CITY OF ALBUQUERQUE

**RE: Wat Phrathat Doi Suthep NM
Grading and Drainage Plans
Engineer's Stamp Date: No stamp
Hydrology File: K19D125A**

Albuquerque Based upon the information provided in your submittal received 09/22/2022, the Conceptual Grading & Drainage Plan is not approved for Administrative Site Amendment until the following comments are addressed:

C-100

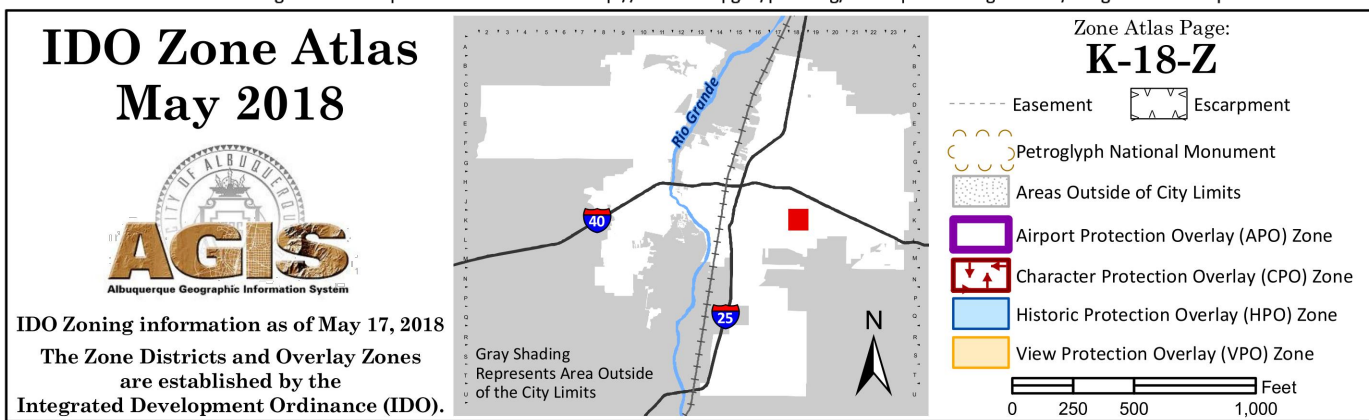
NM 87103 1. Provide for stormwater quality for the proposed impervious area: 0.26" of runoff. Hydrology realizes the area was previously impervious, but when construction is to occur on existing sites stormwater quality must be provided. Provide calculations for the required volume.

www.cabq.gov 2. Remove the Note "There is no stormwater quality volume required...." And remove the statement in the "Conclusions" paragraph that there is no stormwater quality volume required".

3. Do you have a typo in the project name? It ends in "MN" rather than in "NM".

T:\Clients\DWL\Buddhist Temple\New Residence\ACAD\Sheets\C-101_G & D-PLAN_091322.dwg, C-101_G & D, 10/6/2022 13:25:1 PM, Jacques, DWG to PDF.pc3, 1:1

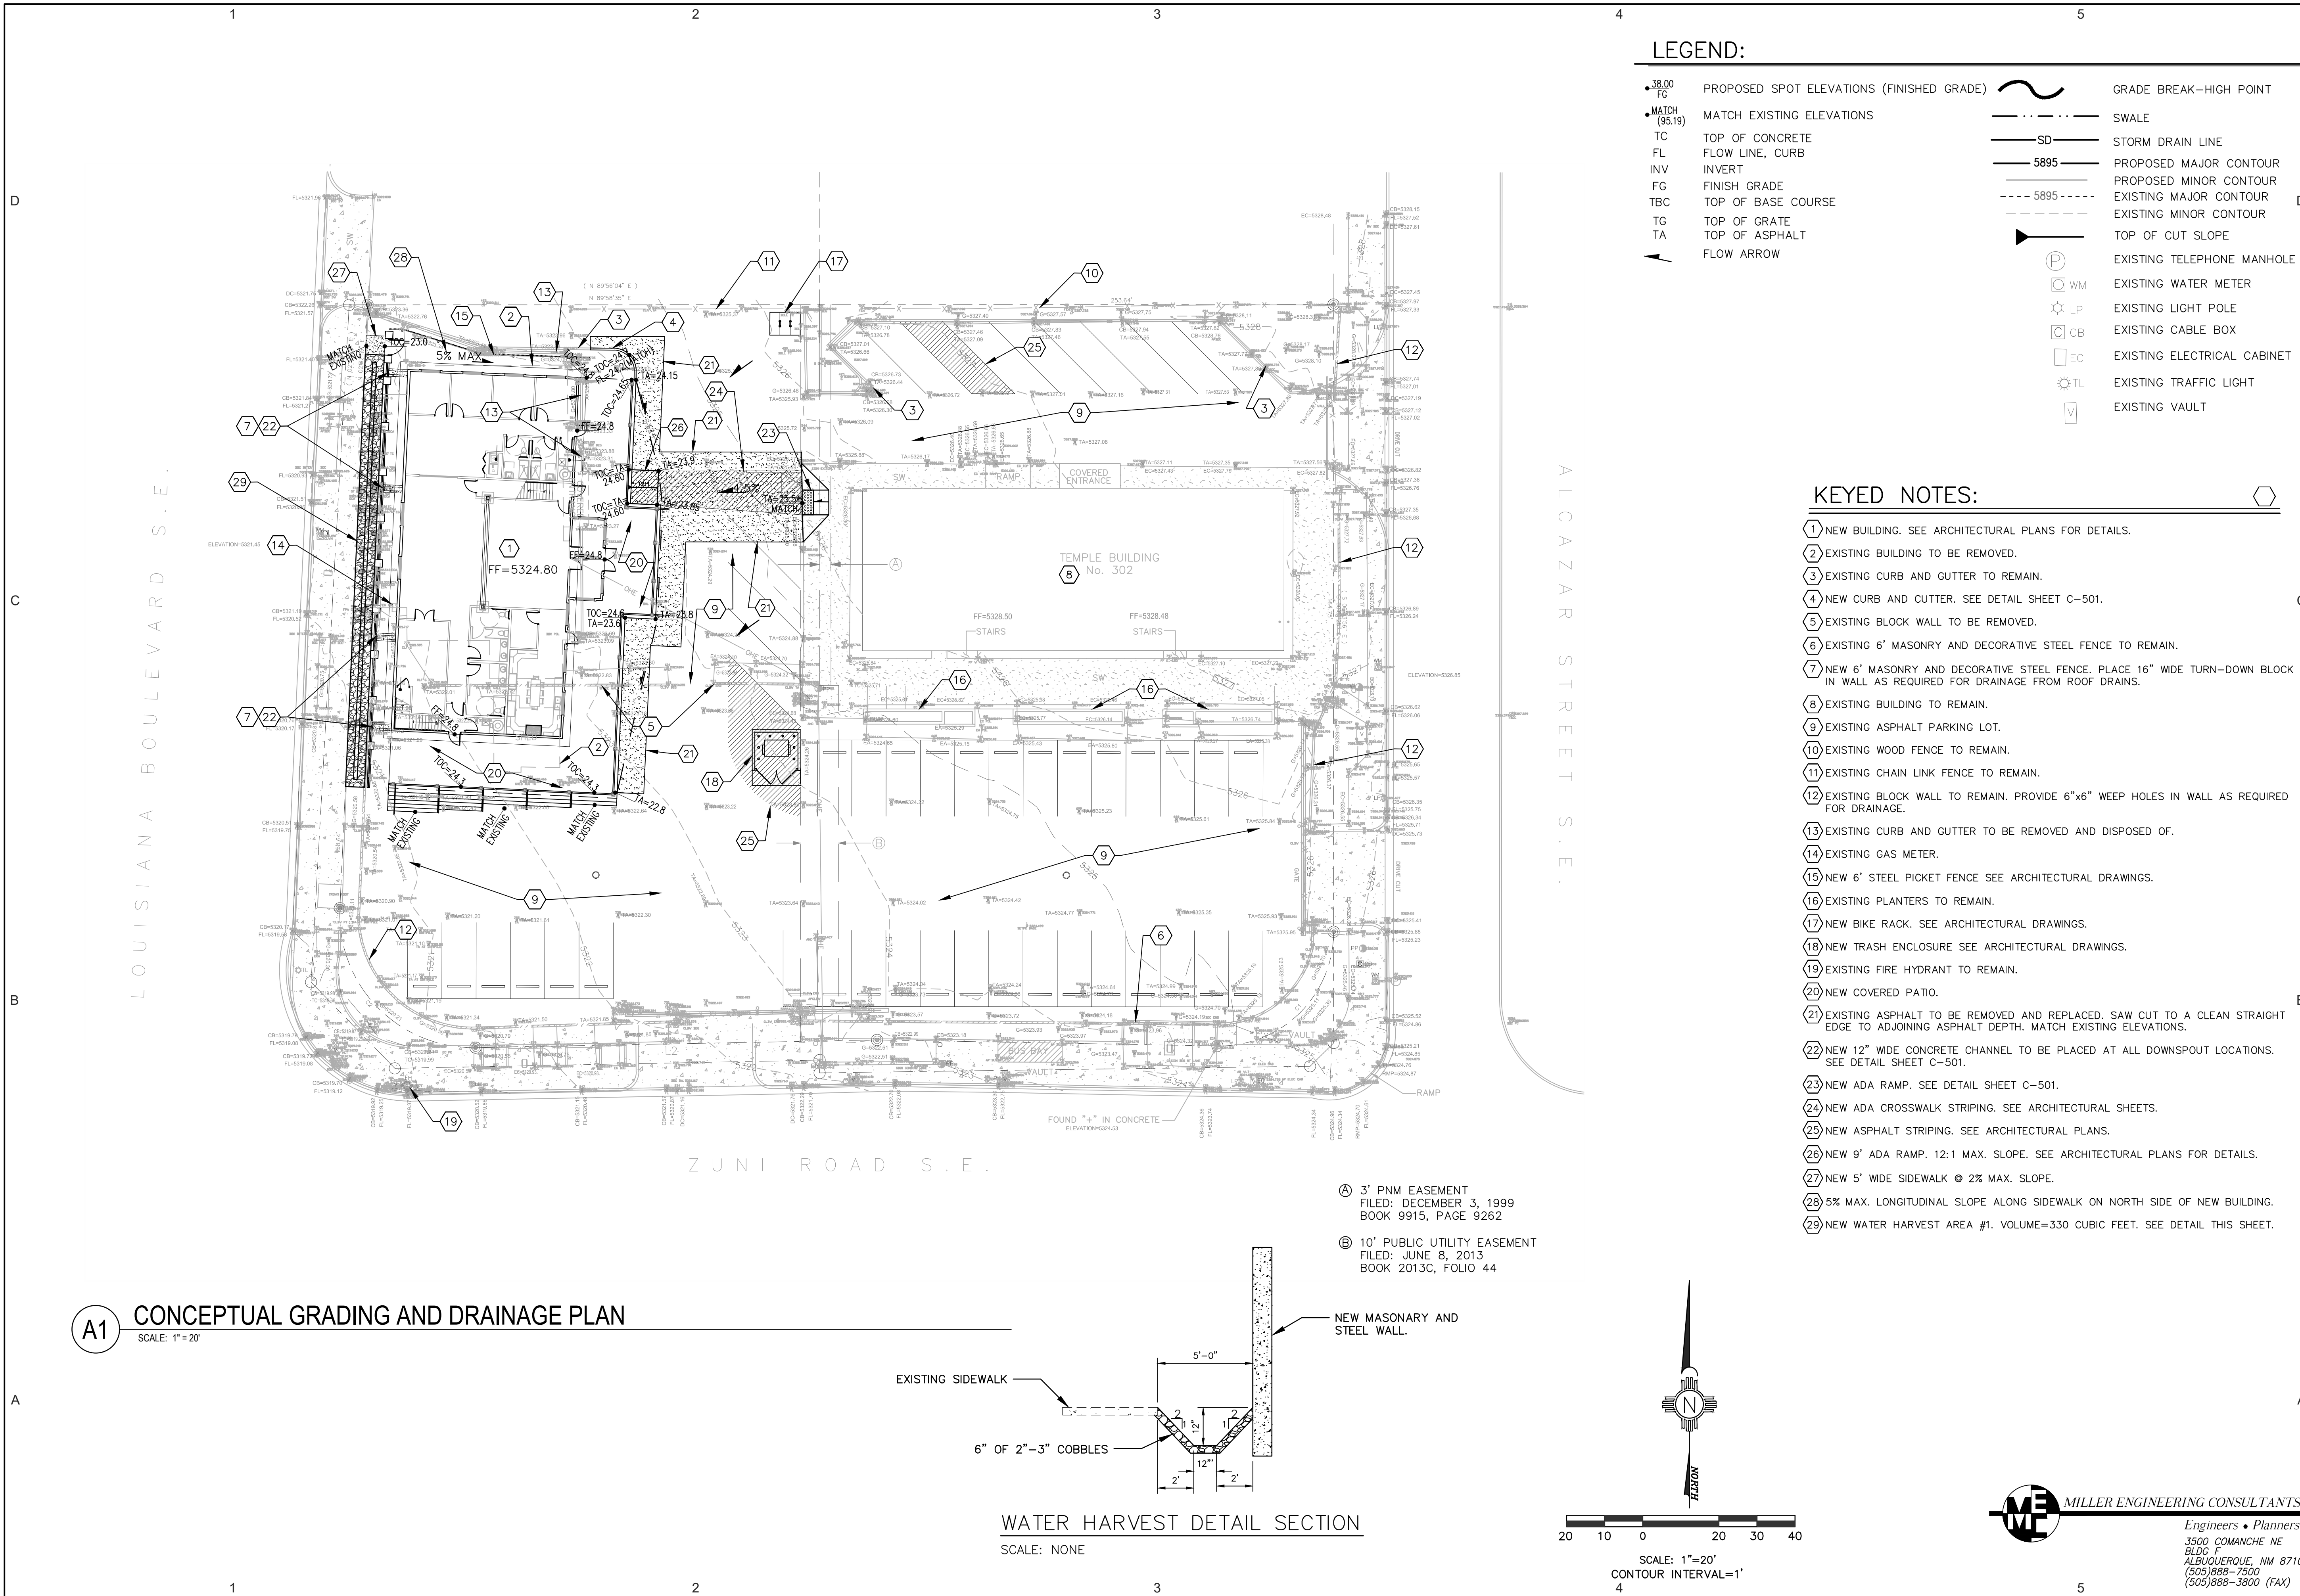
3. It appears there is adequate space for stormwater quality between the wall and the sidewalk along Louisiana Blvd. Provide required volume and provided volume.

1. Keyed Note 22 states to build a 12" wide concrete channel, but the holes in the wall per Note 7 are only 6" wide. Seems the drainage will run into the wall and back-up.

2. Near the NW corner of the new building, it is not clear, what the 2% and 5% MAX applies to. There is also a TOC grade in this area. Seems like a good place for landscaping/stormwater quality ponding area.
